**Rezoning Transportation Analysis**  
**Petition Number: Insert Zoning Petition #2021-045**  
*General Location Identifier: Tax ID 02918118*

Date	Description
04-29-21	First Review (EL)
05-27-21	Second Review (EL)
06-30-21	Third Review (KP)

Petition Number: Insert Zoning Petition #2021-045  
General Location Identifier: Tax ID 02918118

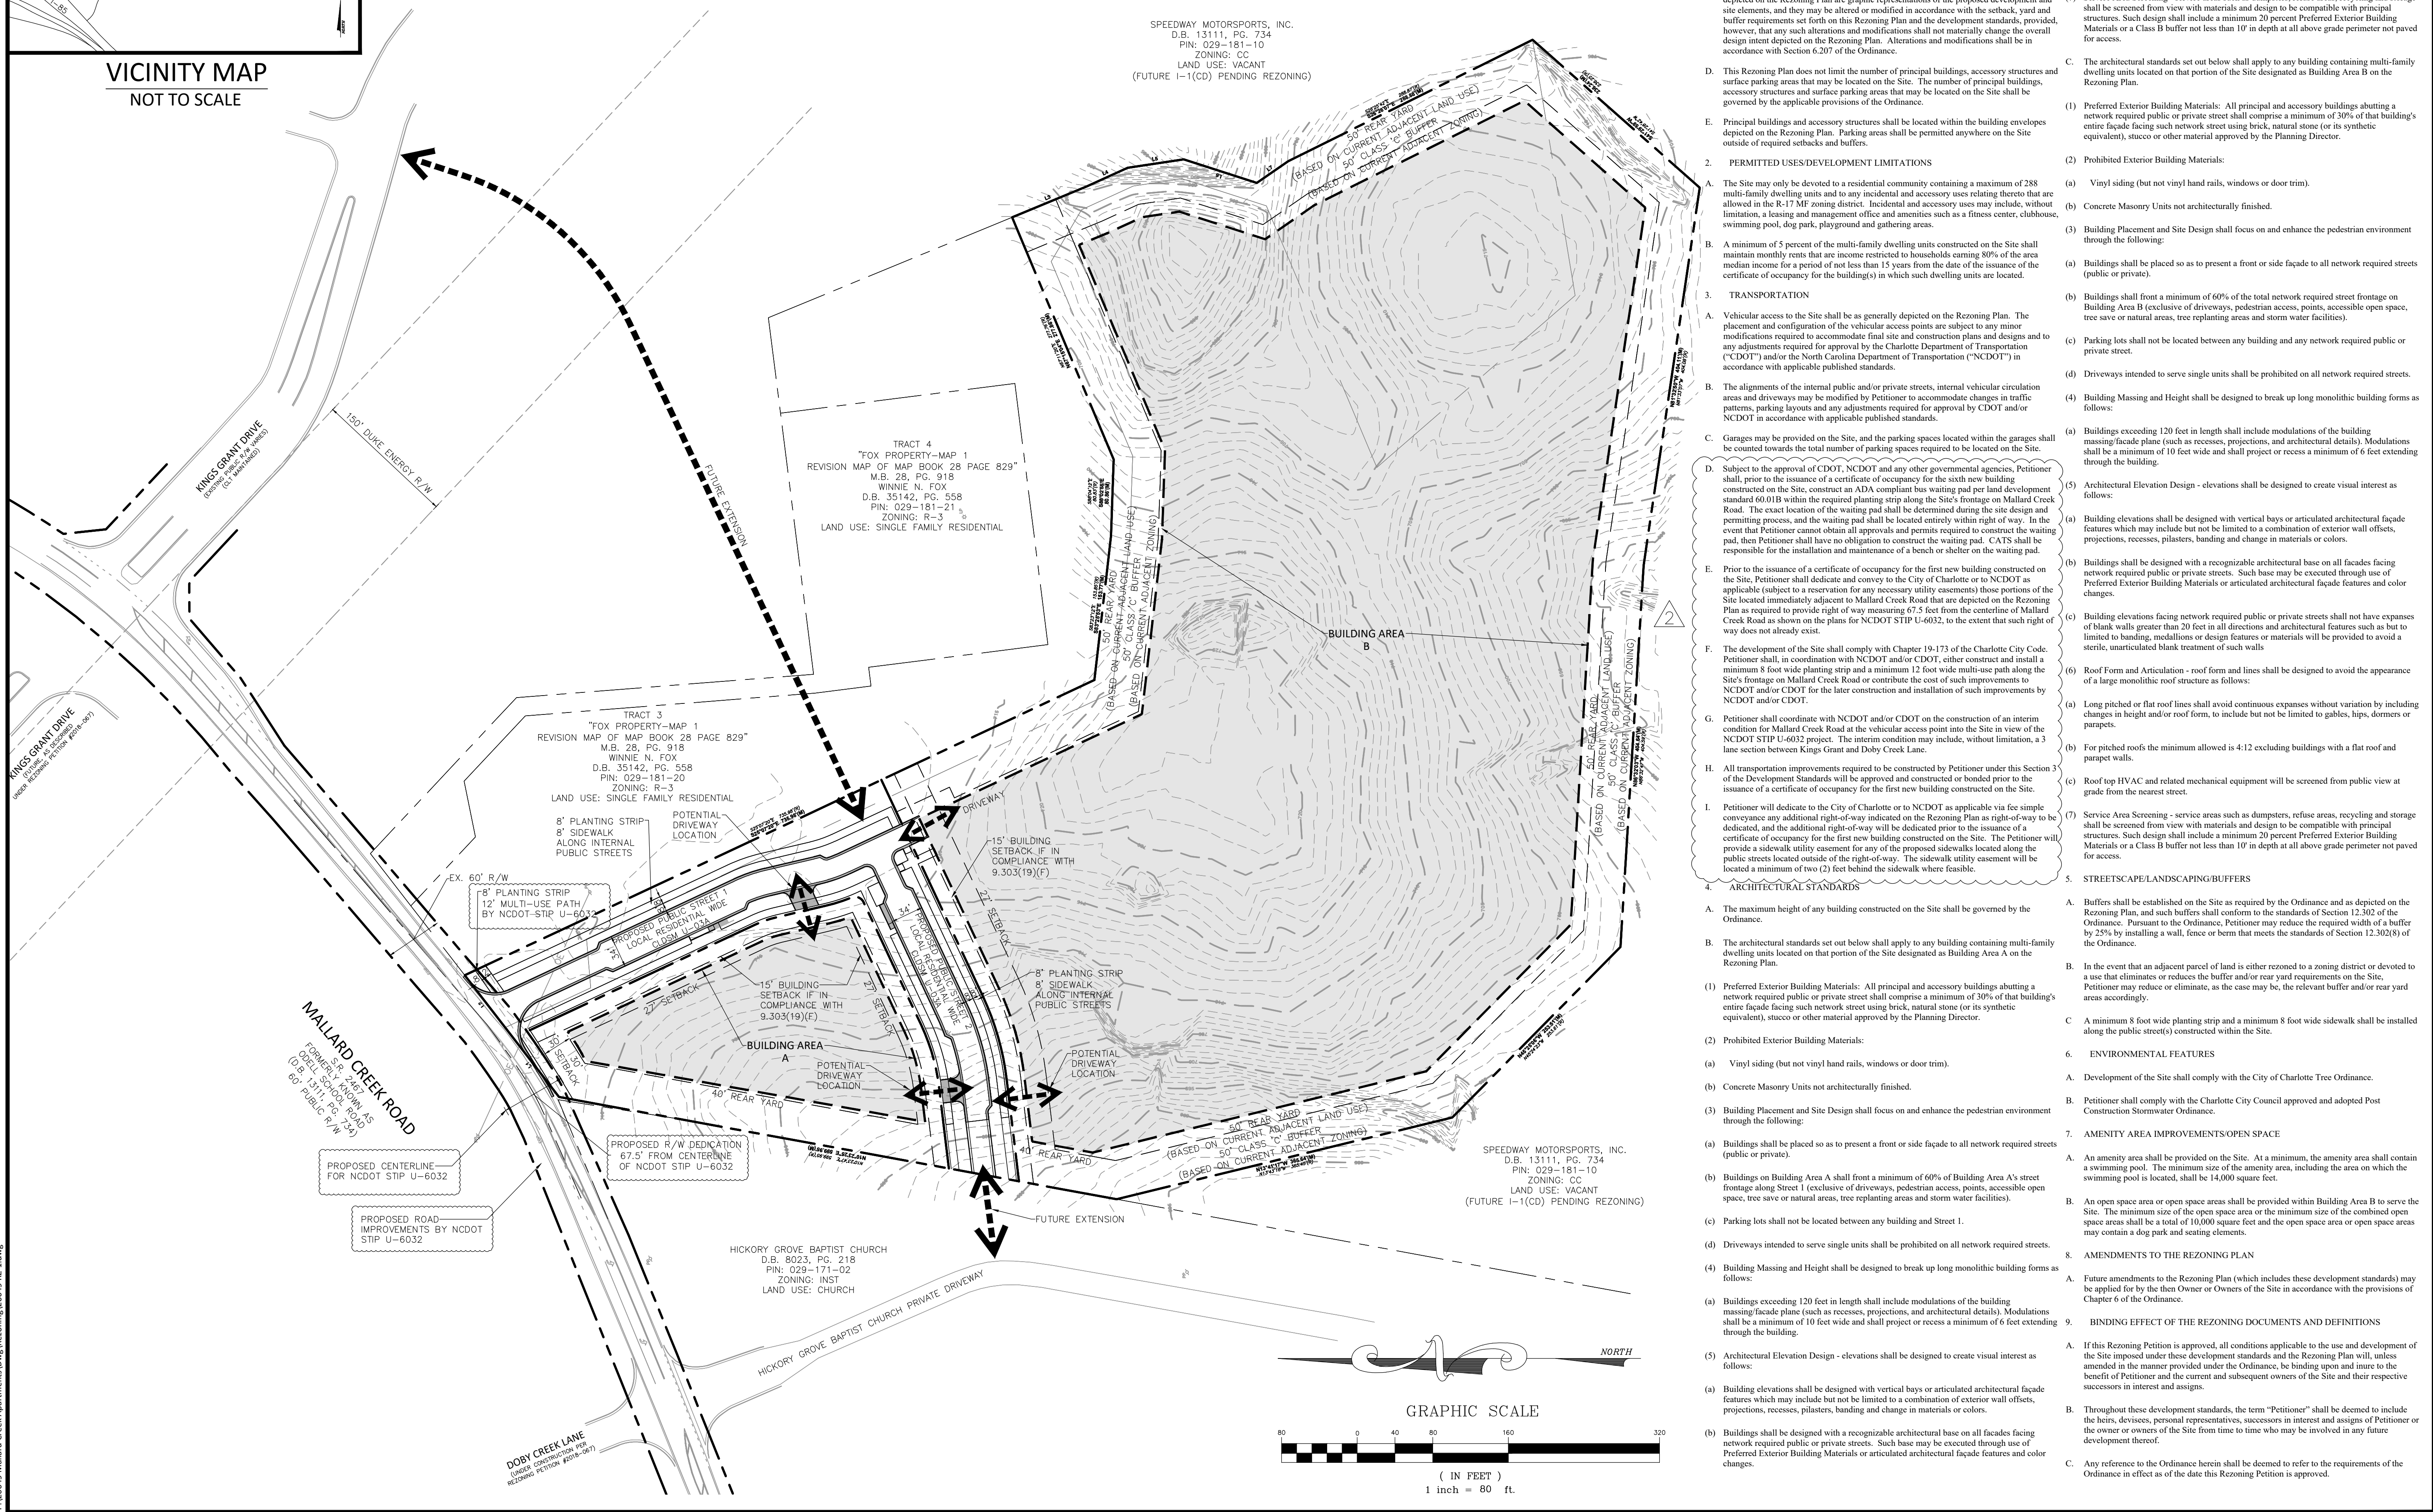
~~7. Update to comment (site plan dated 2021-05-17):~~ Revise the conditional note below to specify that all right-of-way will be dedicated prior to the first building CO. A site plan note(s) specifying dedication and fee simple conveyance of all rights-of-way to the City before the site's first building certificate of occupancy is issued is needed. CDOT requests rights-of-way set at 2' behind back of sidewalk where feasible.

~~8. Update to comment (site plan dated 2021-05-17):~~ Revise all required improvements to be constructed prior to first CO, unless a phasing plan is provided to CDOT for review and approval. A site plan note specifying that all transportation improvements will be approved and constructed before the site's first building certificate of occupancy is issued is needed. The petitioner may phase transportation improvements if said improvements and phasing are explicitly described in site plan notes.

~~9. New comment (site plan dated 2021-05-17):~~ Replace all conditional note references regarding a permanent sidewalk easement to a sidewalk utility easement.

E. Prior to the issuance of a certificate of occupancy for the ~~sixth new building~~ **first** constructed on the Site, Petitioner shall dedicate and convey to the City of Charlotte or to NCDOT as applicable (subject to a reservation for any necessary utility easements) those portions of the Site located immediately adjacent to Mallard Creek Road that are depicted on the Rezoning Plan as required to provide right of way measuring 67.5 feet from the centerline of Mallard Creek Road as shown on the plans for NCDOT STIP U-6032, to the extent that such right of way does not already exist.

H. All transportation improvements required to be constructed by Petitioner under this Section 3 of the Development Standards will be approved and constructed or bonded prior to the issuance of a certificate of occupancy for the ~~sixth new building~~ **first** constructed on the Site.

I. Petitioner will dedicate to the City of Charlotte or to NCDOT as applicable via fee simple conveyance any additional right-of-way indicated on the Rezoning Plan as right-of-way to be dedicated, and the additional right-of-way will be dedicated prior to the issuance of a certificate of occupancy for the first new building constructed on the Site. The Petitioner will provide a permanent sidewalk easement for any of the proposed sidewalks located along the public streets located outside of the right-of-way. The permanent sidewalk easement will be located a ~~minimum of two (2) feet~~ behind the sidewalk where feasible.
